WEST SUSSEX COUNTY COUNCIL CONSULTATION

TO:	Arun District Council
FROM:	WSCC - Highways Authority
DATE:	1 October 2019
LOCATION:	Highdown Industrial Park Littlehampton Road Ferring BN12 6PG
SUBJECT:	FG/74/19/PL 2 No. commercial B1/B8 use buildings with associated car parking, access & refuse storage This application is a Departure from the Development Plan.
DATE OF SITE VISIT:	
RECOMMENDATION:	Advice
S106 CONTRIBUTION TOTAL:	n/a / £ See below for breakdown.

Drawing Title
Site Plan - Location Plan

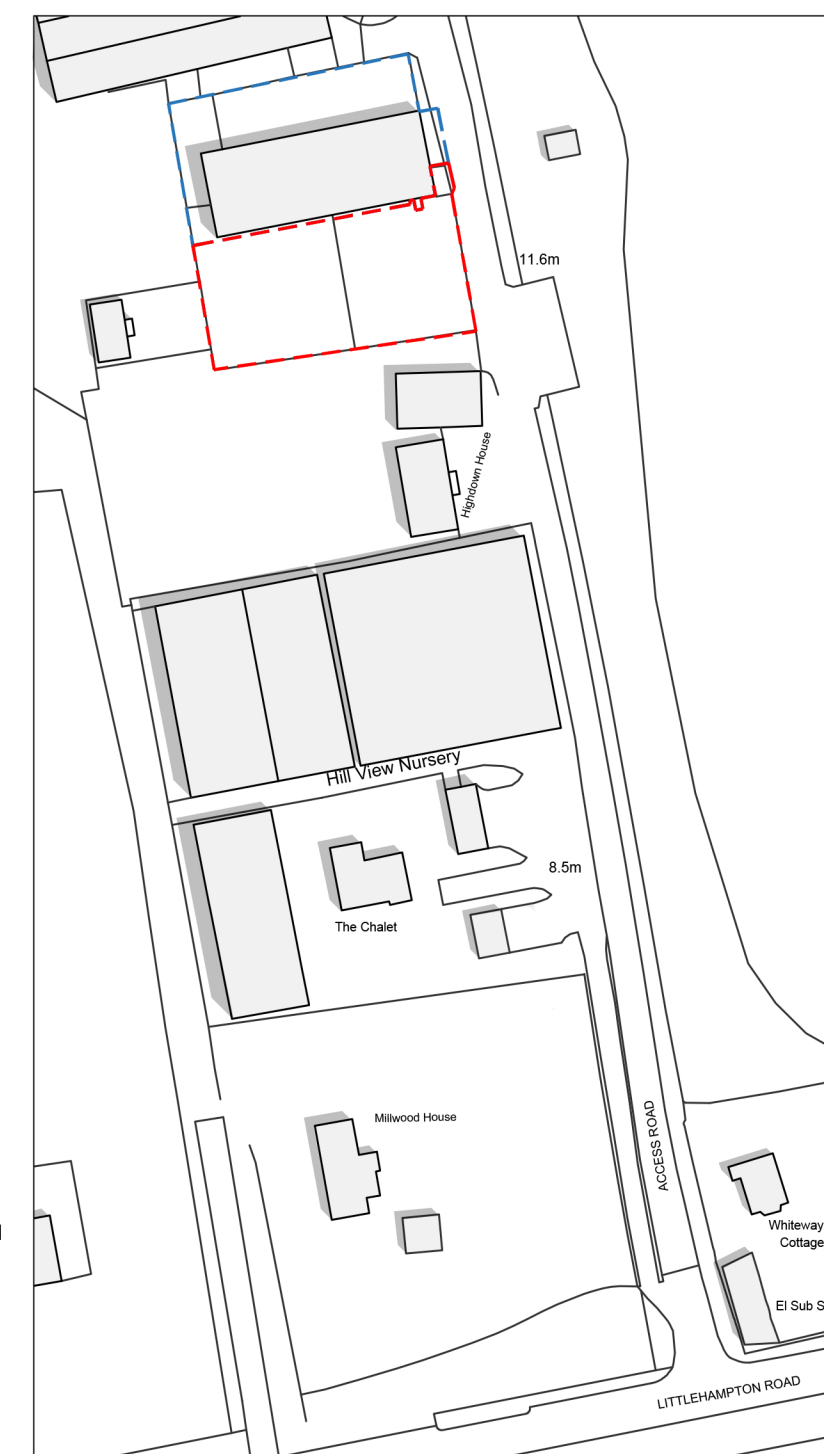
Car parking is provided for 11 cars which are 2.4m x 4.8m and cycle storage is also provided although no showers are proposed. Using the WSCC car parking calculator as a guide the provision of 11 spaces would be in line with standards give or take 10%.

B1 – 1 space per 30sqm (7 spaces)

B8 – 1 space per 100sqm (2 spaces)

Staff and Visitor spaces (aprox 2-4 spaces)
